MECKLENBURG COUNTY
Park and Recreation Department

MEMORANDUM

DATE: September 20, 2023

RE: Rezoning Petition #2023-028
PID# 02959103

SHEET NUMBER  
**RZ-1**

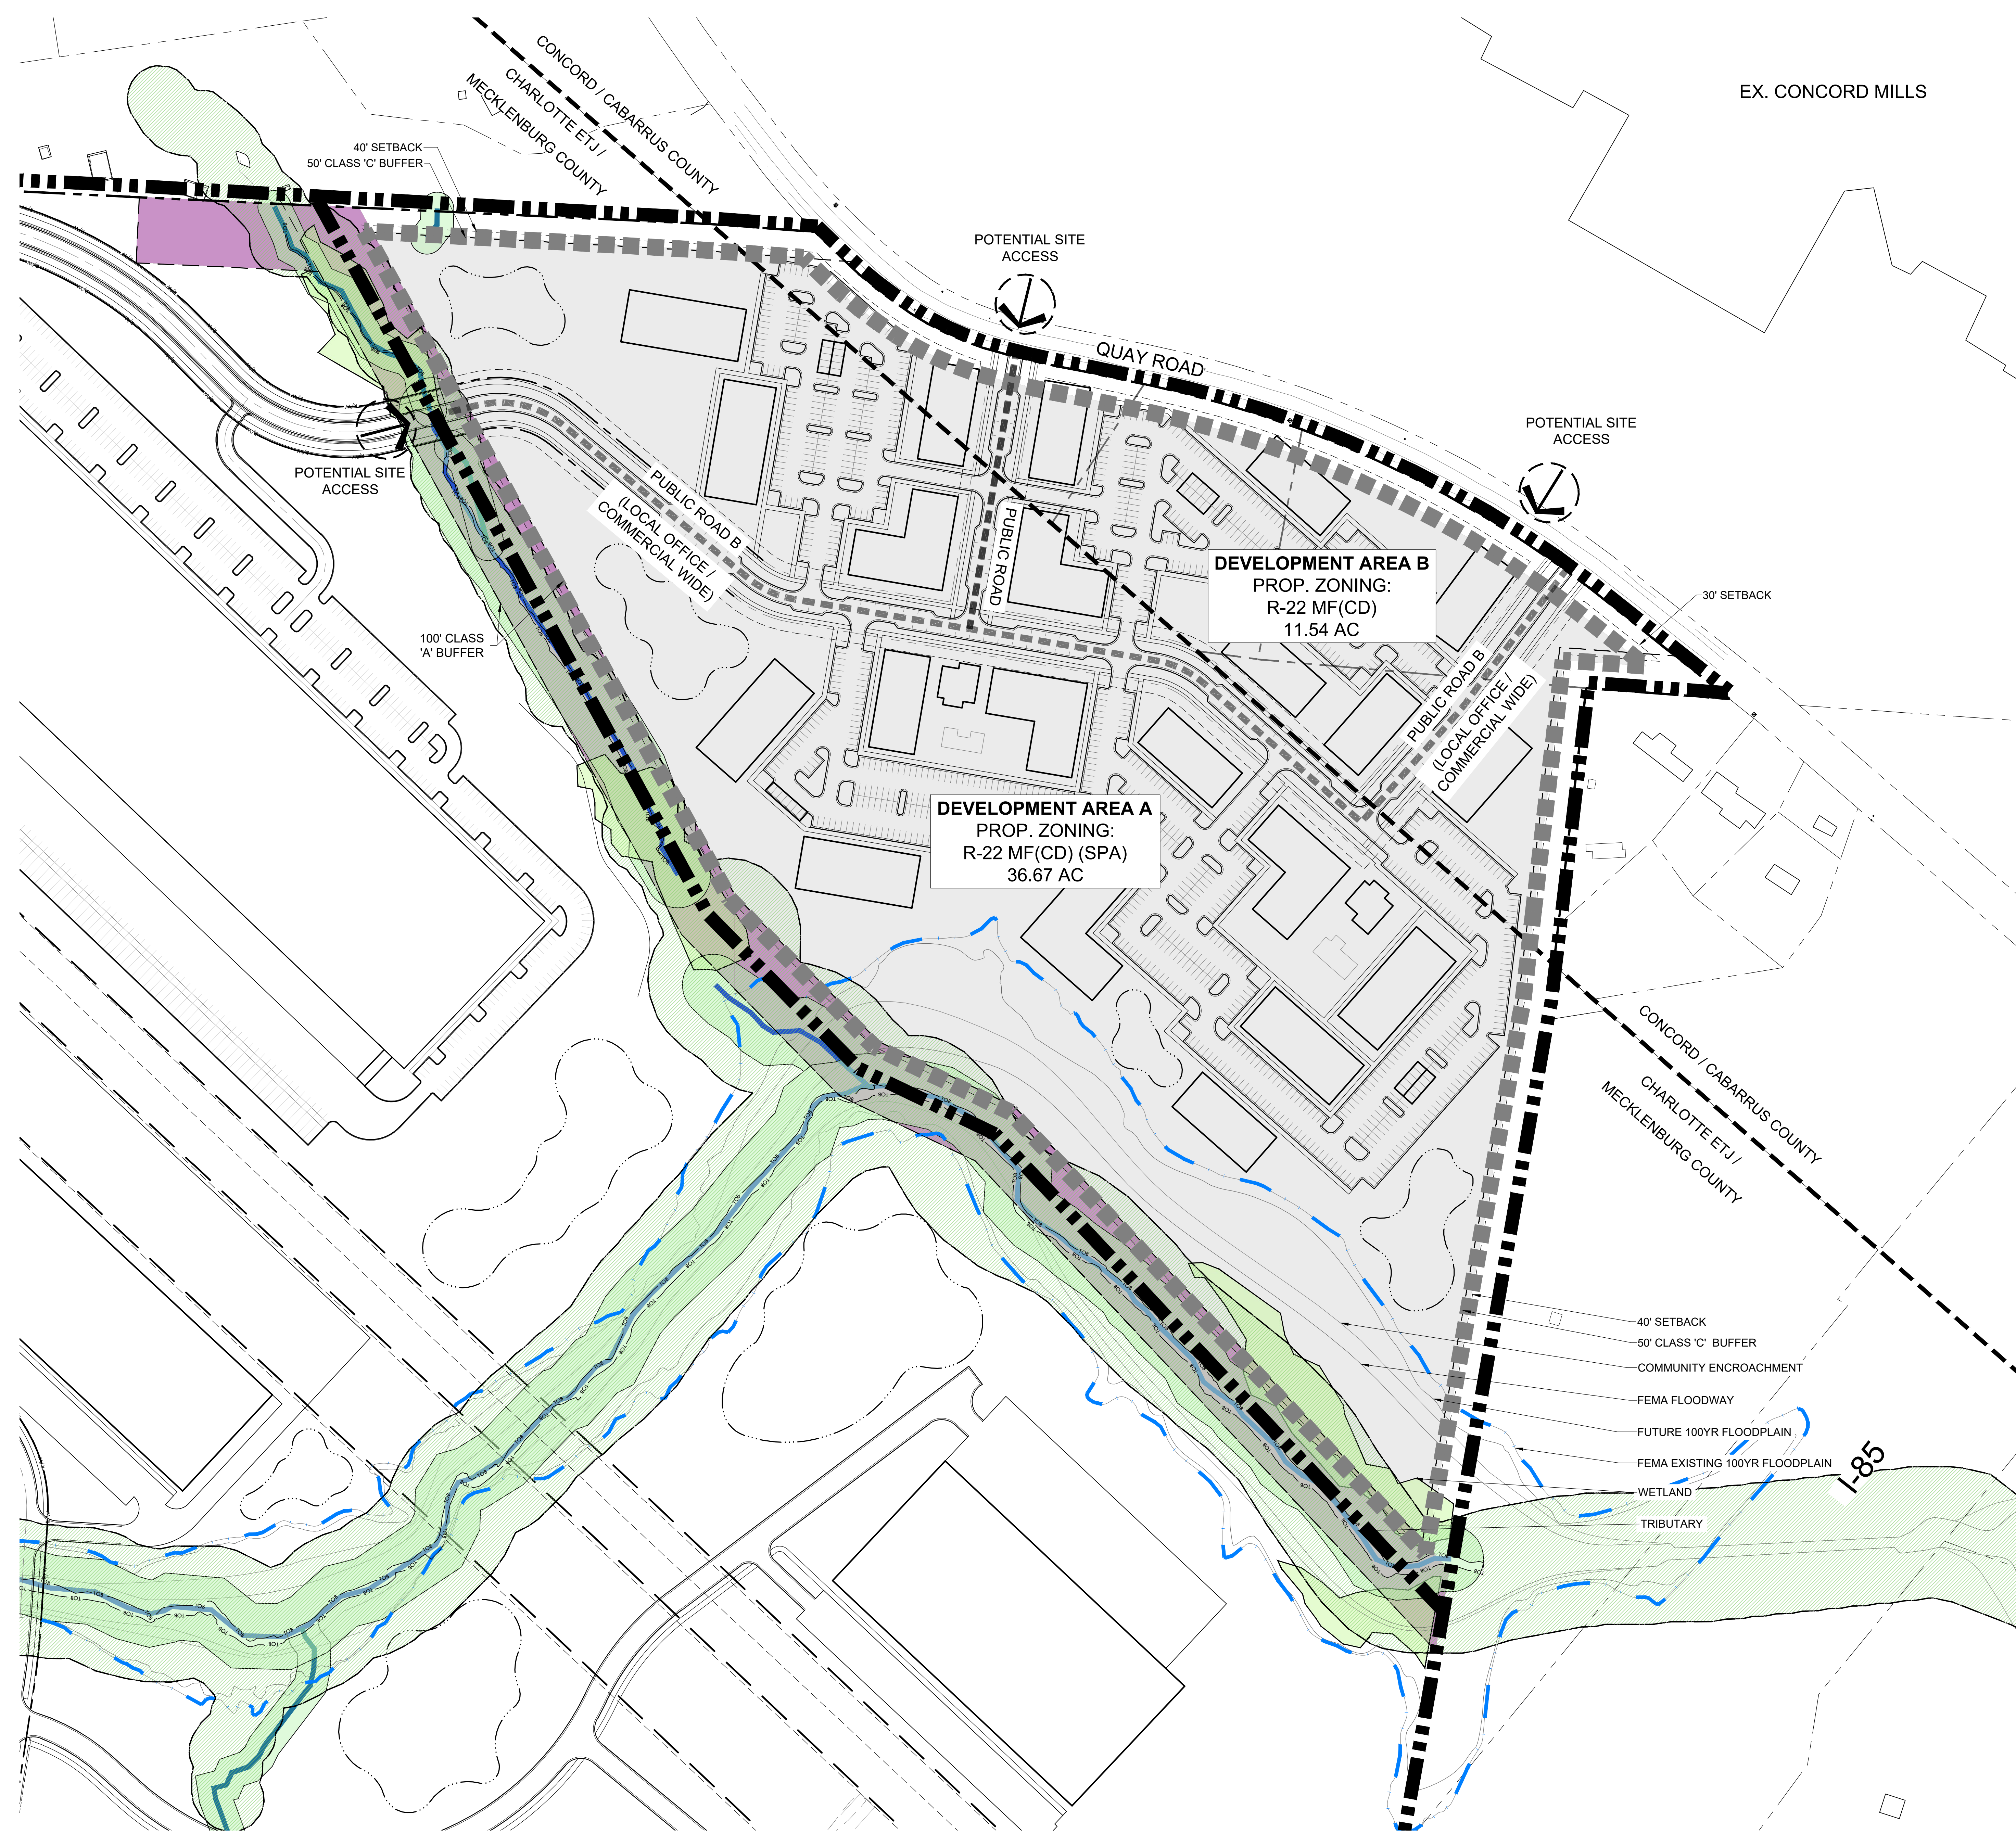
Plans current reference previous Park and Recreation commitments from Rezoning 2021-028. MCPR requests that the petitioner accommodates a minimum of 1.8 acres of the 12-acre park dedication commitment on this site. Note that the requested park land shall be adjacent to a public right-of-way for access and should provide connectivity to the larger 12-acre park land area on the adjacent development.
